# CITY OF ALBUQUERQUE

**Re: Lot 12-A, Block 2 University Heights Addition  
222 Yale Blvd SE  
Request Permanent C.O. - Accepted  
Engineer's Stamp dated: 4-28-14 (K16D032)  
Certification dated: 11-11-14**

**RE: University Height, Lot 12-A Block 2**  
**Grading and Drainage Plan**  
**Engineer's Stamp Date 4-28-2014 (K16D032)**

**LOT 12-A, BLOCK 2, UNIVERSITY HEIGHT ADDITION
GRADING AND DRAINAGE PLAN**

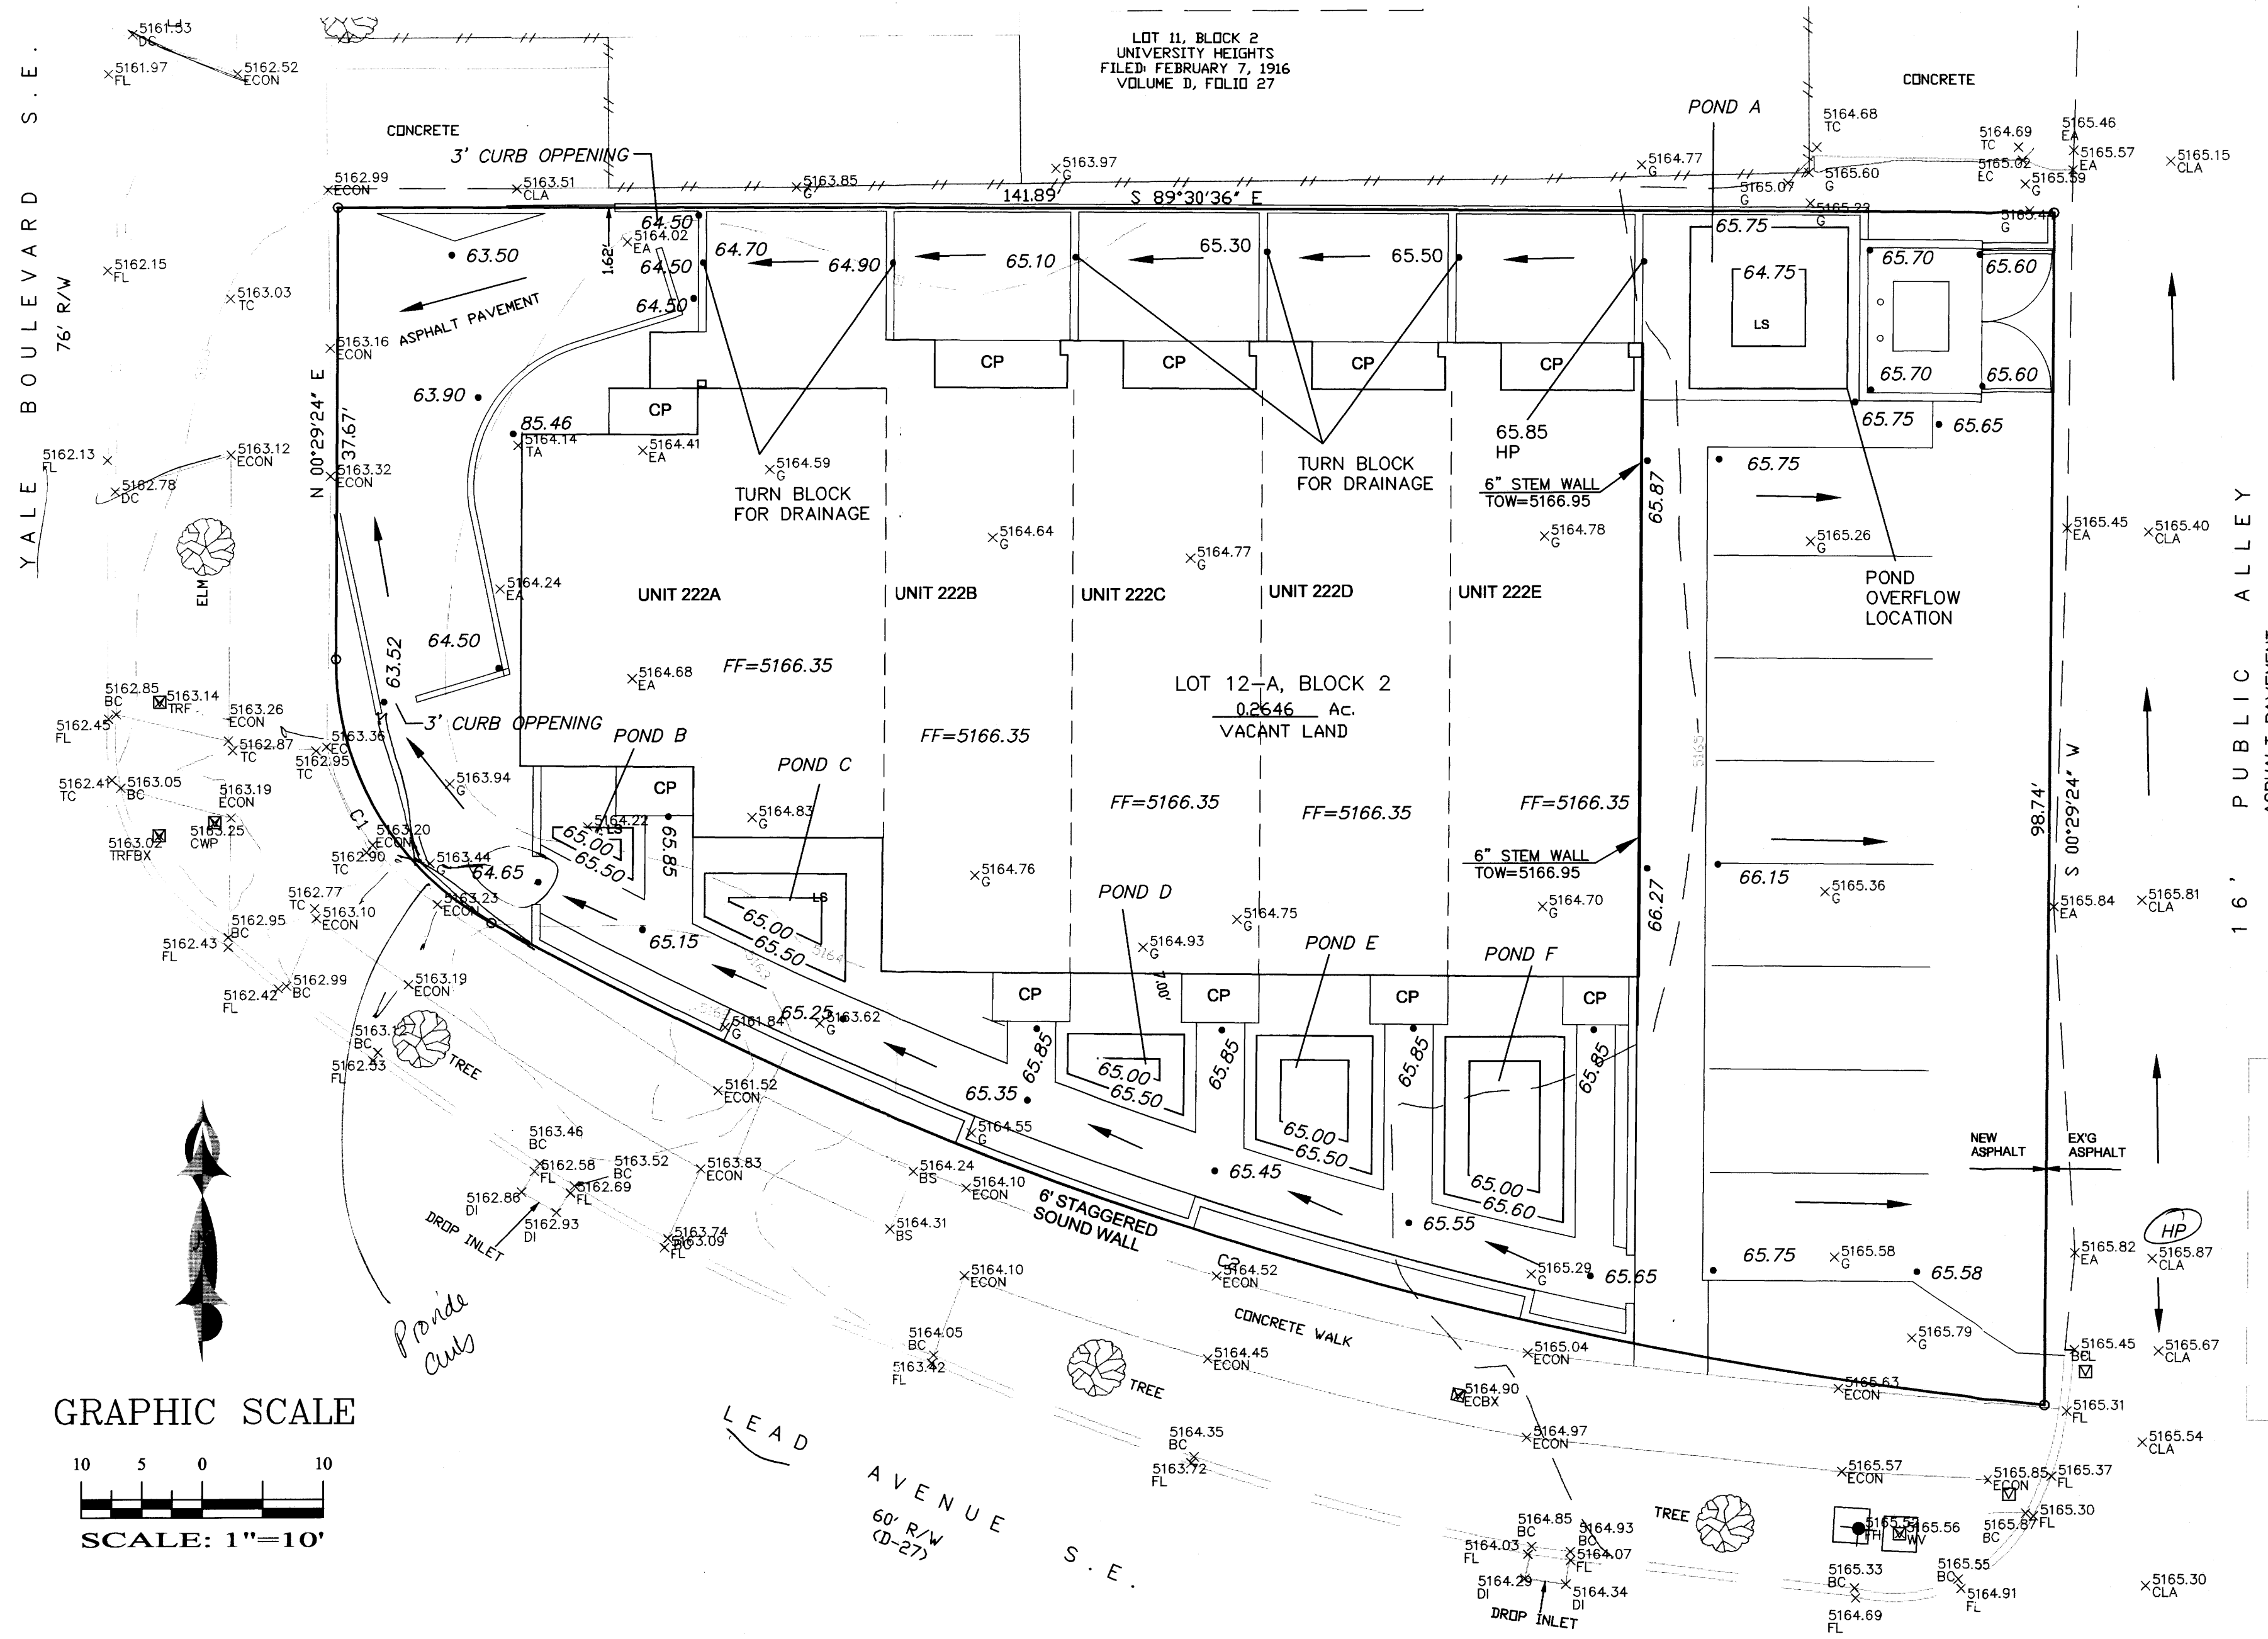
- It appears flows on southwest corner outfall to corner rather than thru drivepad. Provide berm, curb or similar to direct flow to outfall at drivepad and to support flow arrows.
